Our Ref: R/243/11/
Your Ref:

The Town and Country Planning Act 1990 (as amended)
Town and Country Planning Development Management Procedure Order 2010 (as amended)

Proposed renovations & additions
Herne Farm House 2 Park Drive Rustington

PROPOSED ELEVATIONS

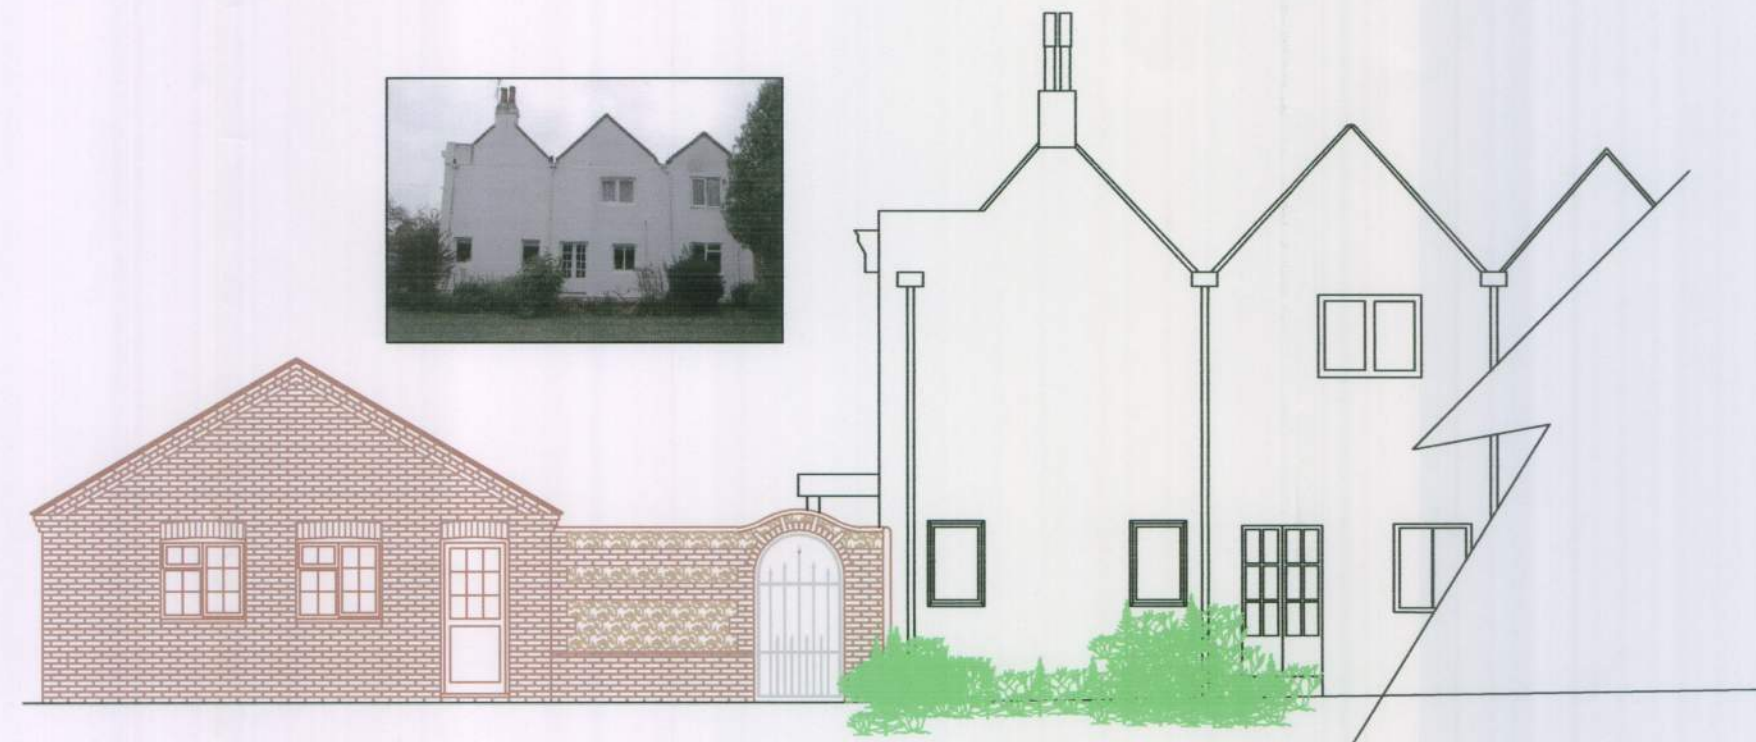
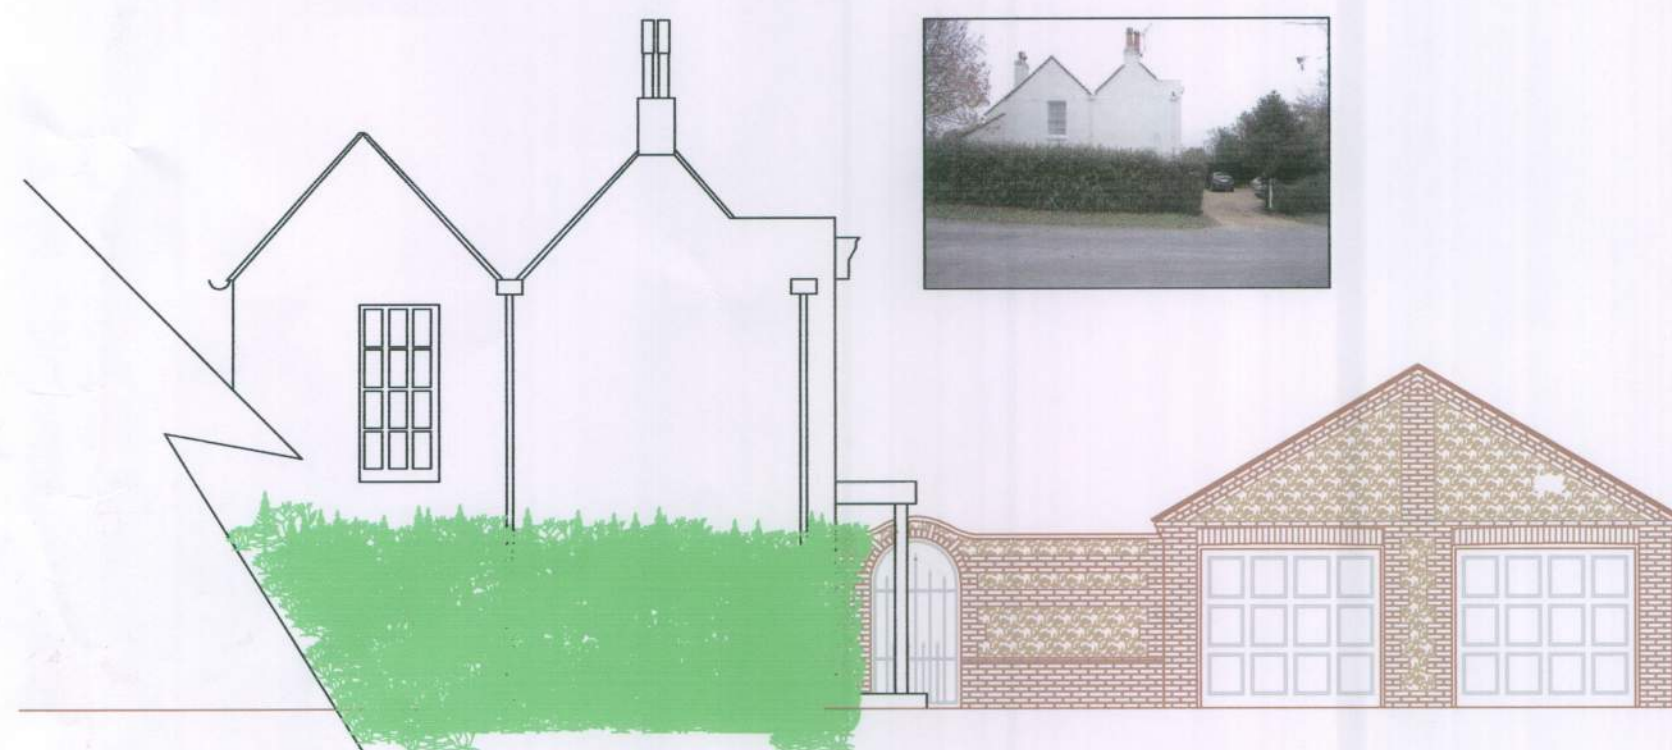
Please provide 1 electronic or 3 paper copies of proposed east and west elevations of the main dwelling to show the proposed connecting wall to the garage and a revised proposed side elevation of the garage. The archway shown does not accord with the floor plan and site plan
